Application for Planning Permission for Works or Extension to a Dwelling

Development Create a dropped curb & vehicle cross over

Location 40 Wick Street Littlehampton

**Drawing:
Block and site plans**

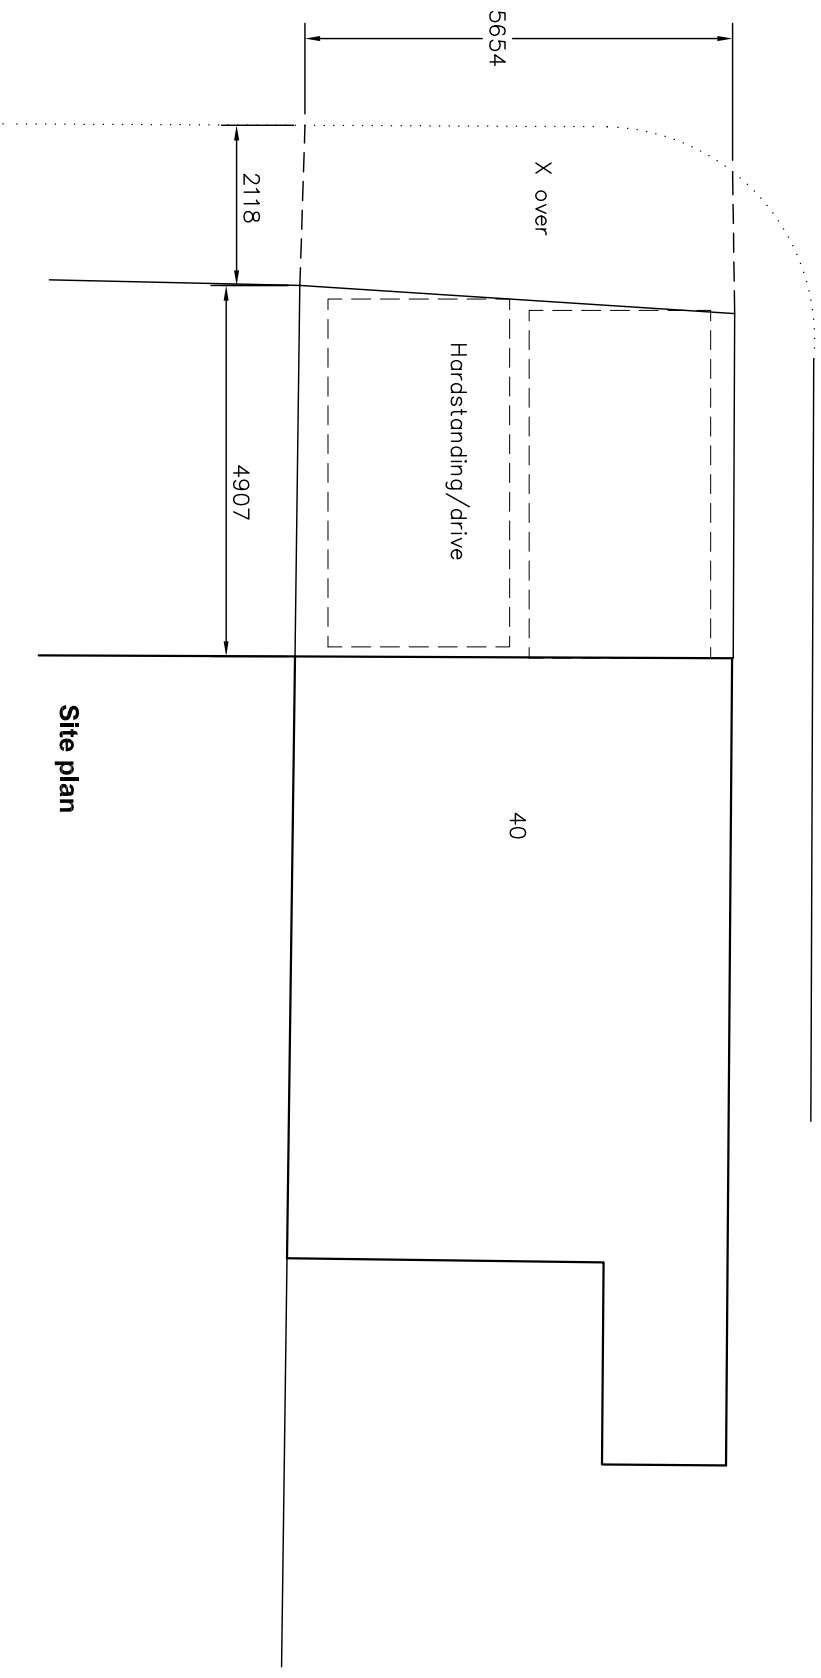
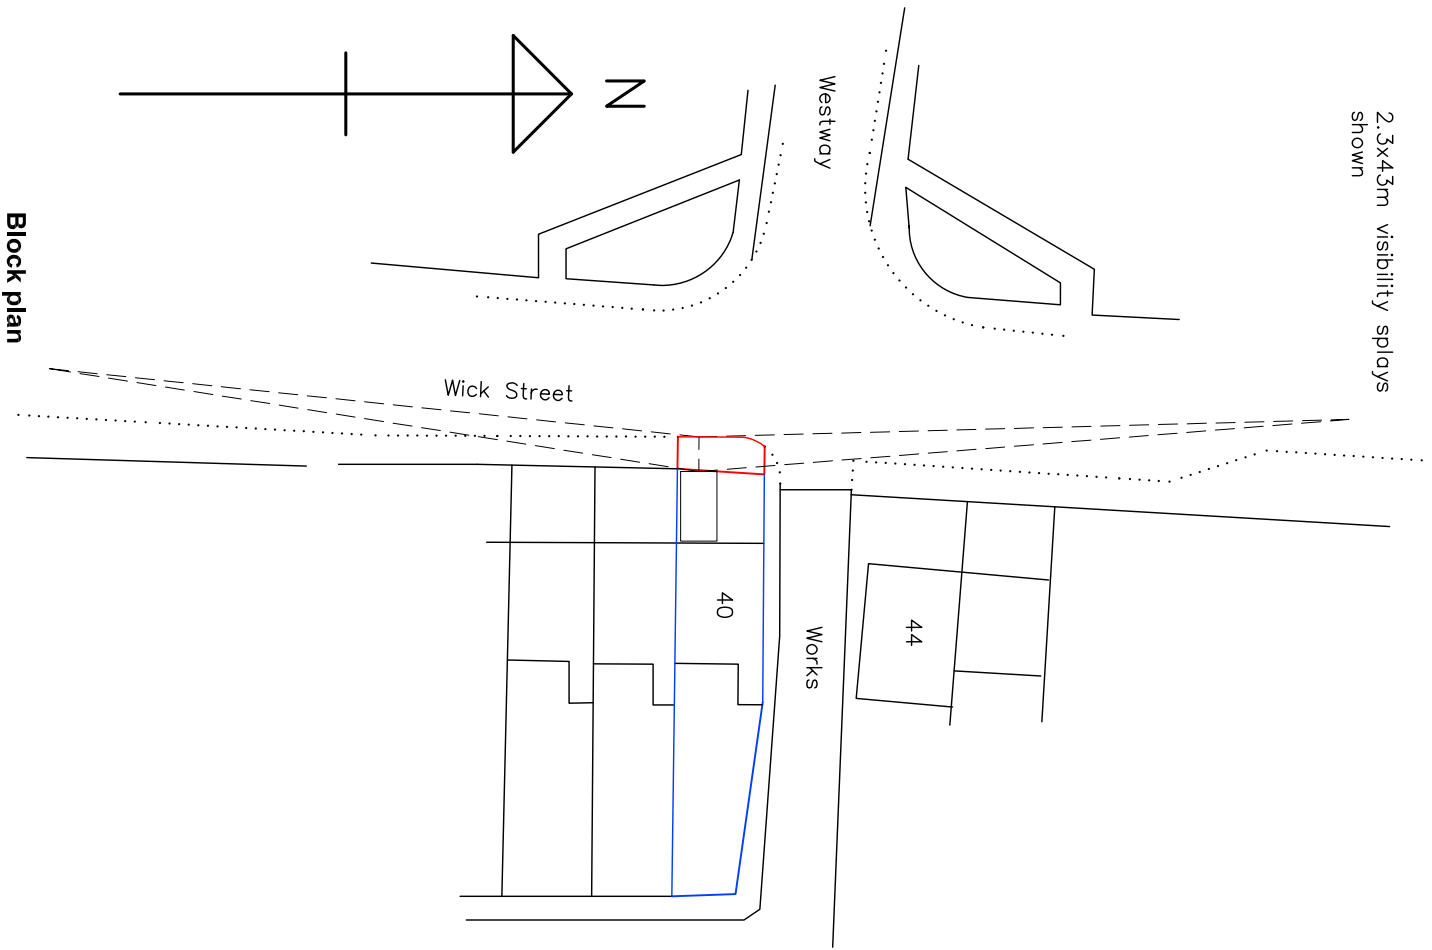
Please submit 1 electronic or 3 paper copies of existing and proposed floor plans or layout plan at a scale of 1:100 showing clearly the proposed crossover and highway in accordance with the guidance notes available on our website detailed below (click on National List).

Please indicate clearly the visibility splays on either the Block plan or the site layout plan, if you have any queries regarding visibility splays then please contact West Sussex County Council.
